Planning and Urban Development Department

Date: May 23rd, 2014

Re: **May 27th, 2014 Planning Board Workshop**
 Level III Site Plan and Subdivision Review
 5-unit multi-family building
 97 Cumberland Avenue
 Peter Dugas, Applicant

EXTERIOR FINISH SCHEDULE	
MATERIAL TYPE	MATERIAL DESCRIPTION
AL1	Aluminum Clad Window Frame
M1	Cold Formed A606 Steel Panel Siding - 20" x 10"
PW1	Painted Wood Trim
ST1	Acrylic Stucco Over Rigid Insulation
WS1	Vertical Shiplap Siding

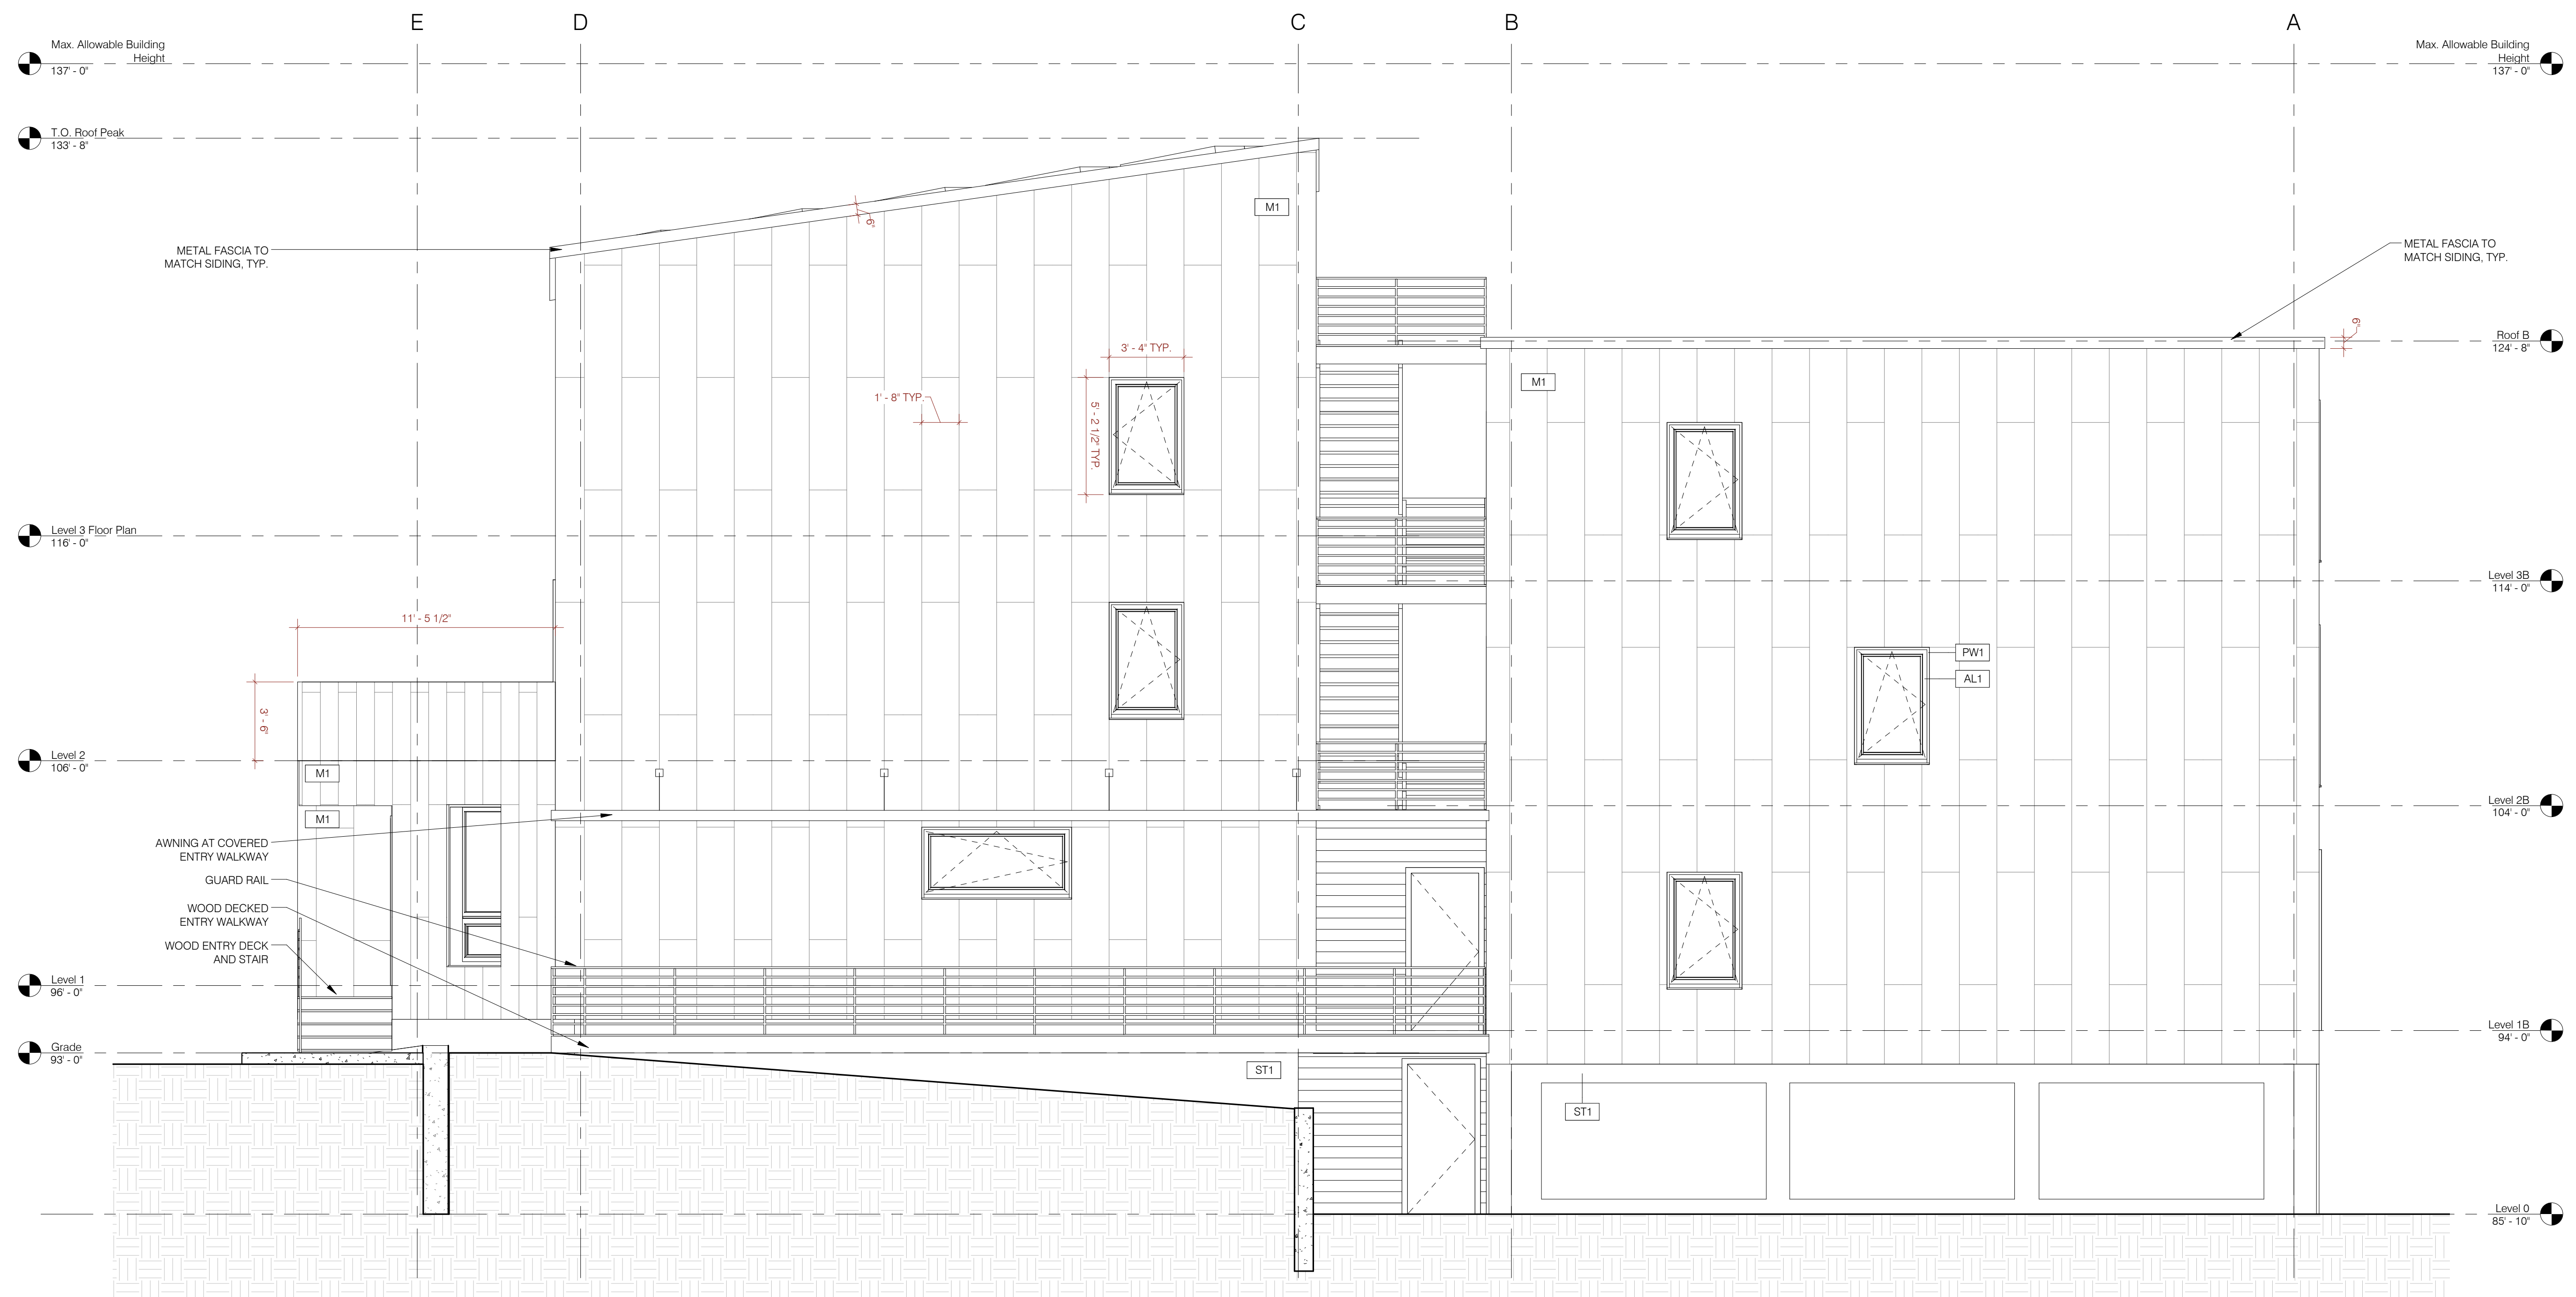
The proposals, including floor plans and elevations, are shown in the Plan set. The proposed building has 3 levels in the front part and 4 levels in the rear section, with parking on the lowest level. The overall building height is approximately 40 feet as shown in the elevations ([Plans P10](#)).
